**From:** Charlotte Watkins <[Charlotte.Watkins@Cherwell-DC.gov.uk](mailto:Charlotte.Watkins@Cherwell-DC.gov.uk)>  
**Sent:** Tuesday, May 7, 2024 10:15 AM  
**To:** Laura Bell <[Laura.Bell@Cherwell-DC.gov.uk](mailto:Laura.Bell@Cherwell-DC.gov.uk)>  
**Subject:** 24/00539/F - Land To The East Of Stratfield Brake And West Of Oxford Parkway Railway Station, Oxford Road, Kidlington

24/00539/F  
Ecology response  
Land To The East Of Stratfield Brake And West Of Oxford Parkway Railway Station, Oxford Road, Kidlington

Figure 4.7 - Landscape Site Wide GA Plan

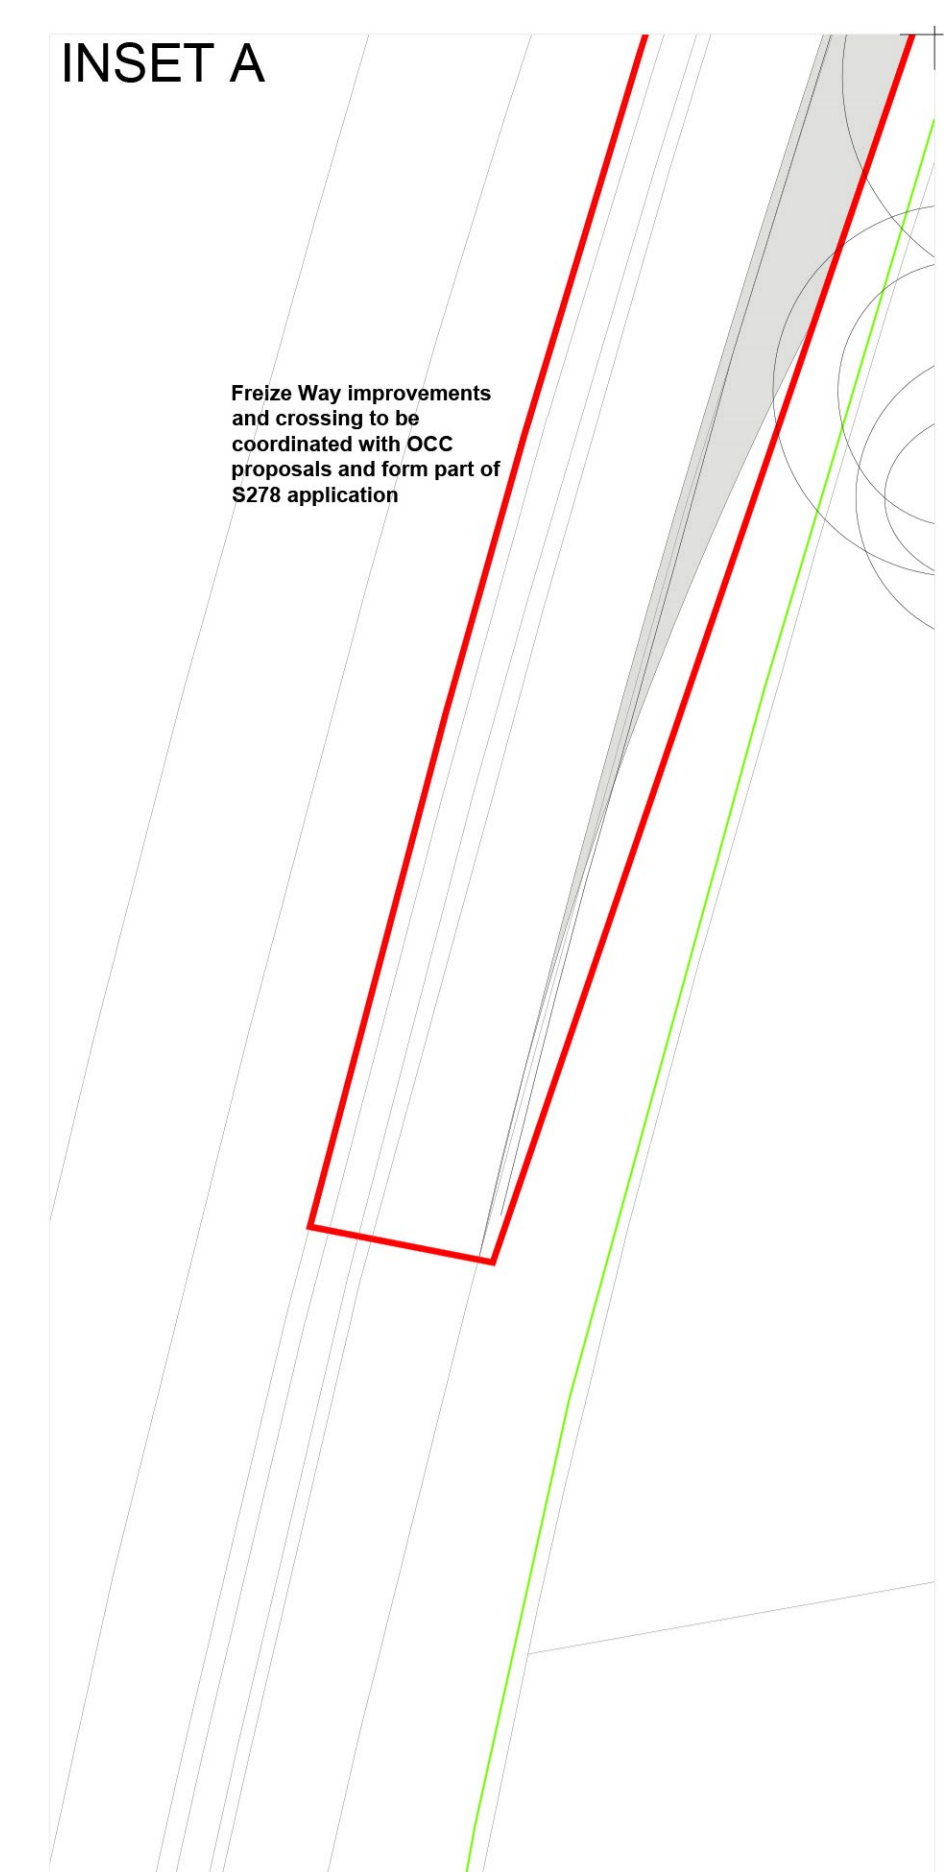
The metric shows 81 medium trees and 62 small trees will be planted on site however it is unusual to plant 'medium' sized trees (certainly in this number) as trees are semi-mature at this size with girths of more than 94cm. The illustrative landscape masterplan (OUFC-FAB-00-XX-DR-L-1000-P18) states at key point 15 that '81 trees of *girth* 30cm or above will be planted', however this would not make them 'Medium' trees under the metric guidelines – these should be put in as 'small' trees. 'Medium' is 30cm *diameter at breast height*. If they propose to plant the 81 trees at 30cm girth they would count as 'small' trees (or a diameter at breast height of around 9.5cm..) and this would result in an overall net loss on site.

If they do propose to plant 'medium' trees they need to change the wording in the illustrative masterplan to '**diameter** of 30cm or more' and justify how they will achieve the successful planting of trees this size. Whilst a Habitat Management and Monitoring Plan can be submitted post decision, a draft HMMP would help with demonstrating how the habitats and targets can be achieved.
